KITTITAS COUNTY DEPARTMENT OF PUBLIC WORKS

RE: Big Creek PUD

It is my understanding that Big Creek PUD will soon go to public hearing (07-14-2016). Public Works has reviewed the preliminary PUD map supporting the proposal. We have the following comments based on our review of the preliminary PUD map:

Illustrative Master Plan
Big Creek
 A Planned Unit Development
 Kittitas County, Washington

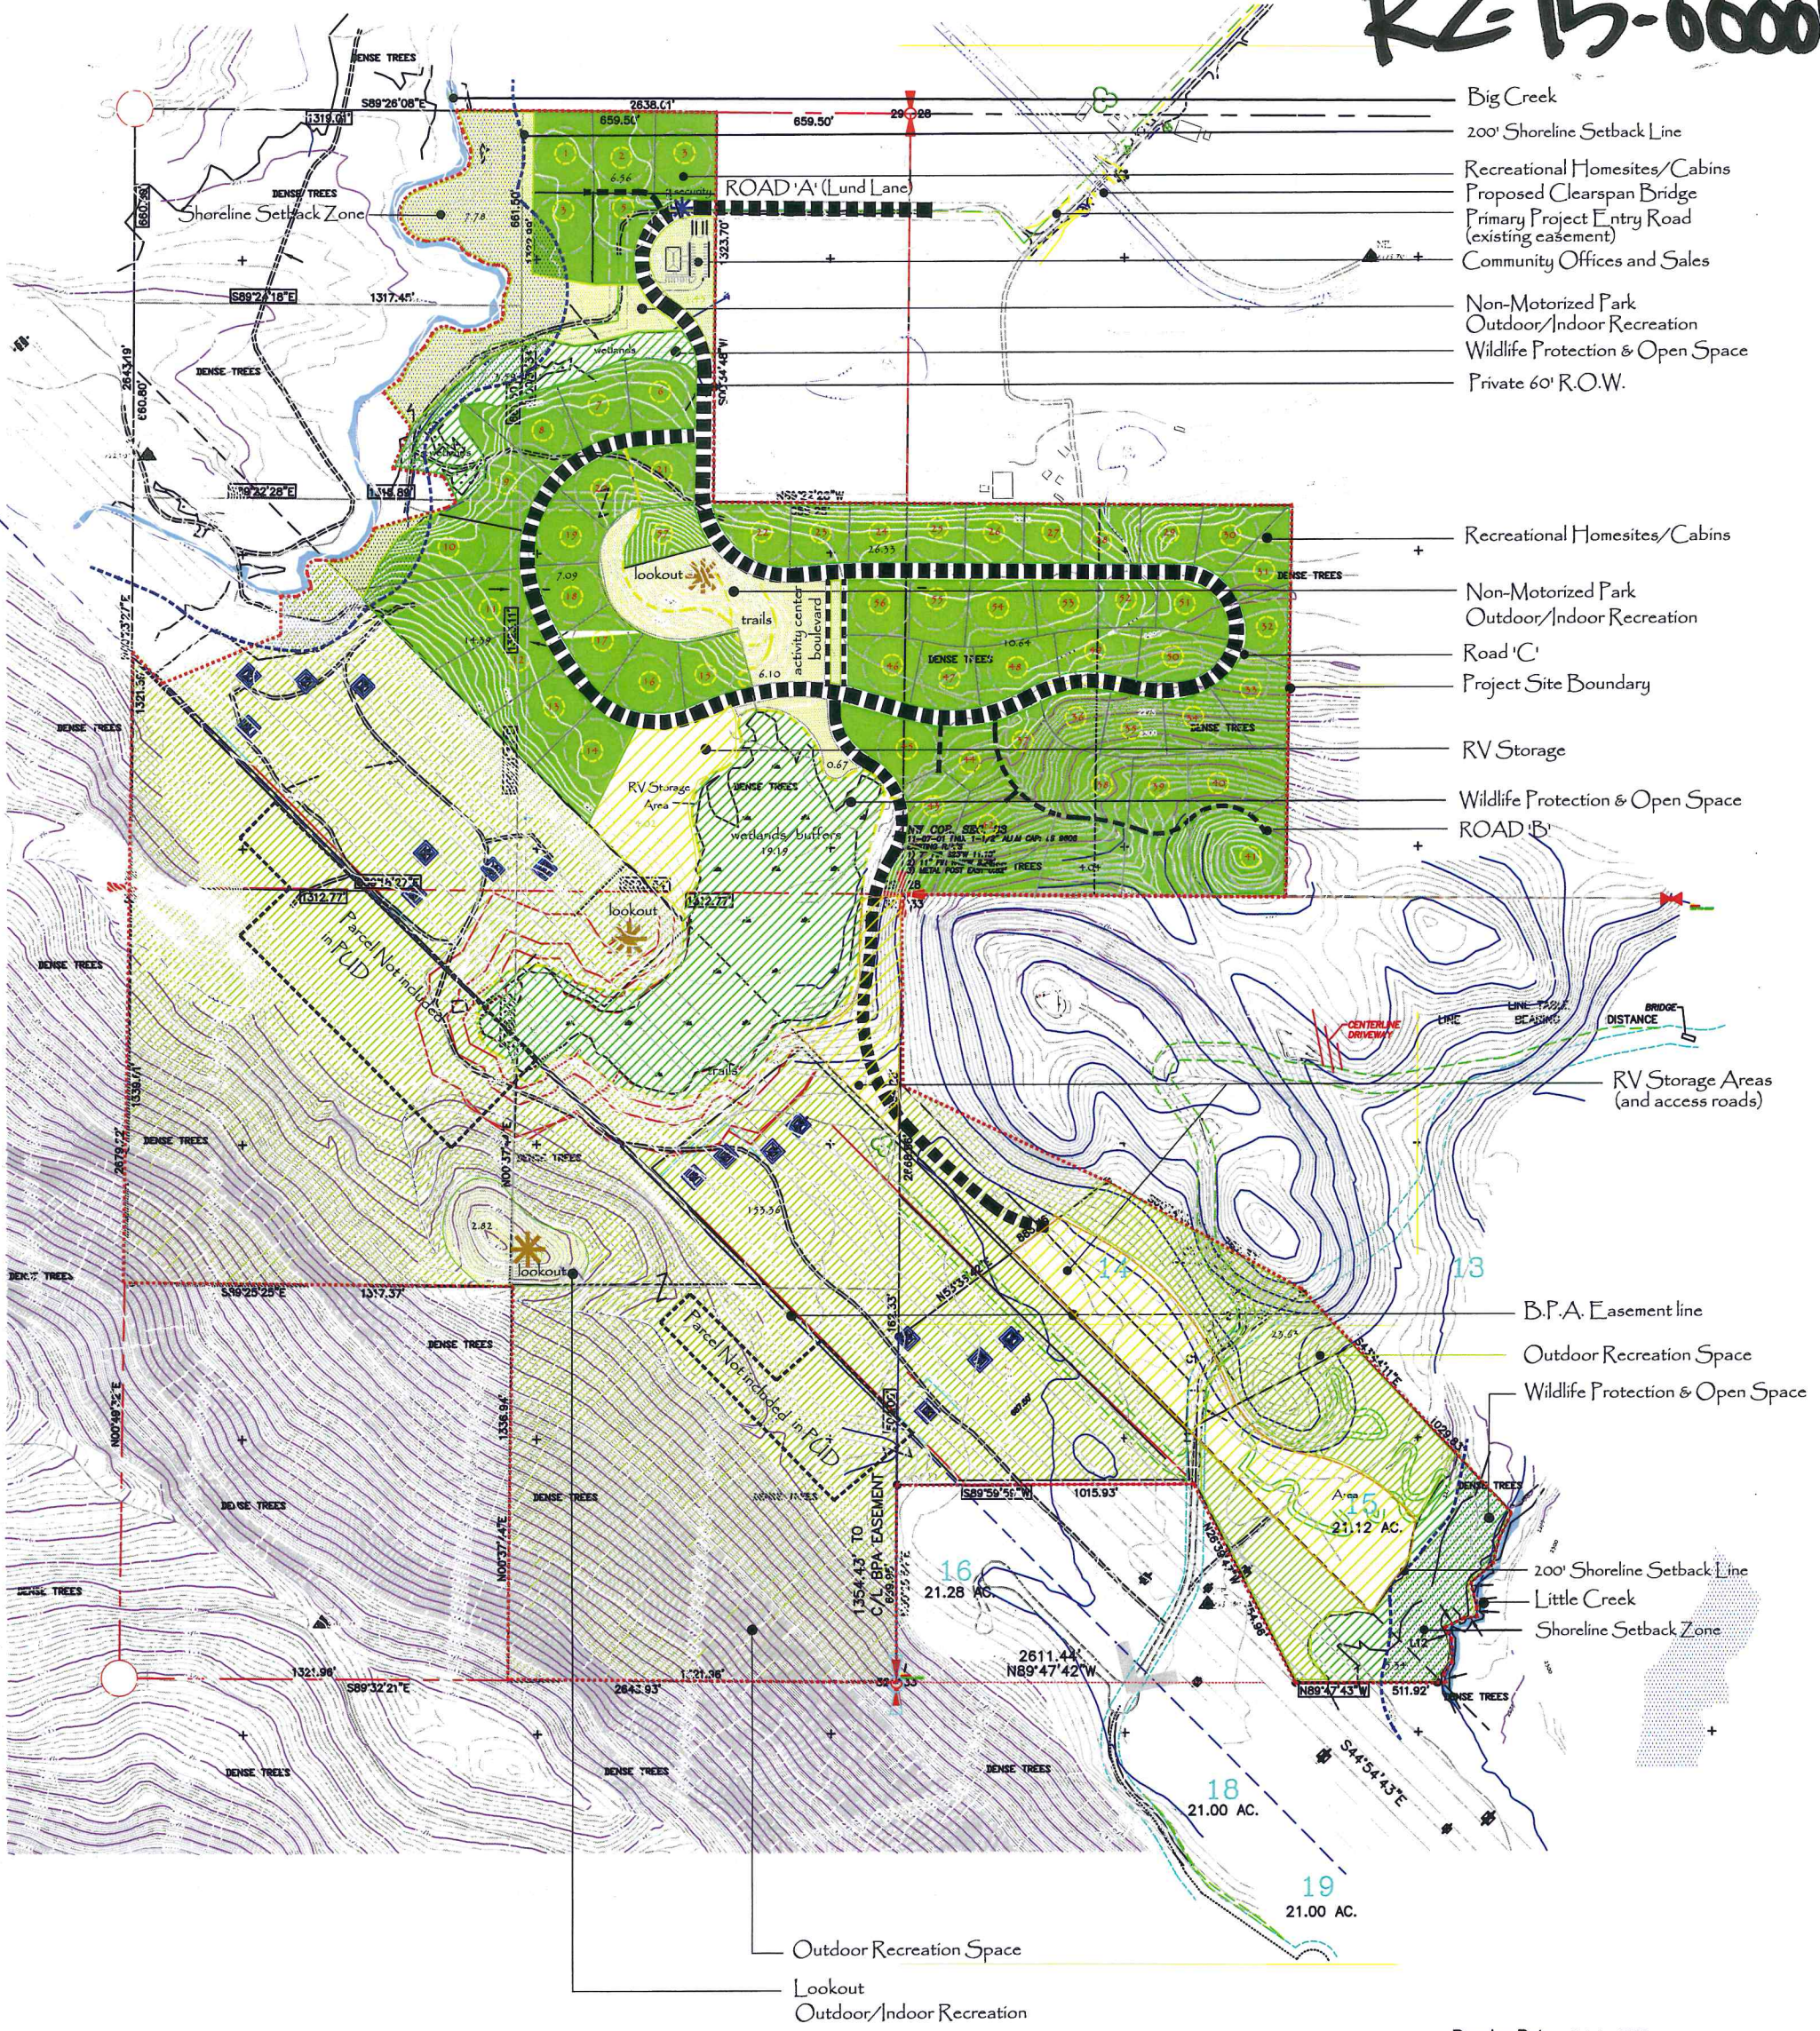
- Public Works desires the extension of Lund Lane and the crossing of the irrigation canal be built to a public road standard. This provides maximum fire-life-safety access for emergency responders.
- Construction of "A" Road to a public standard supports the identified number of lots served by the roadway.
- Construction of "B" Road to current private road standards is acceptable. The terrain suggests that an all-weather surface be required
- The dashed line immediately west of "B" Road is assumed to be a driveway providing access to lot 43. Alternately, a private road may be built serving lots 44, 45 and 43.
- The southerly most road depicted on the map shall be extended to tie into Misty Mountain Way (minimally the right of way – 60 foot - shall be dedicated for future connection).
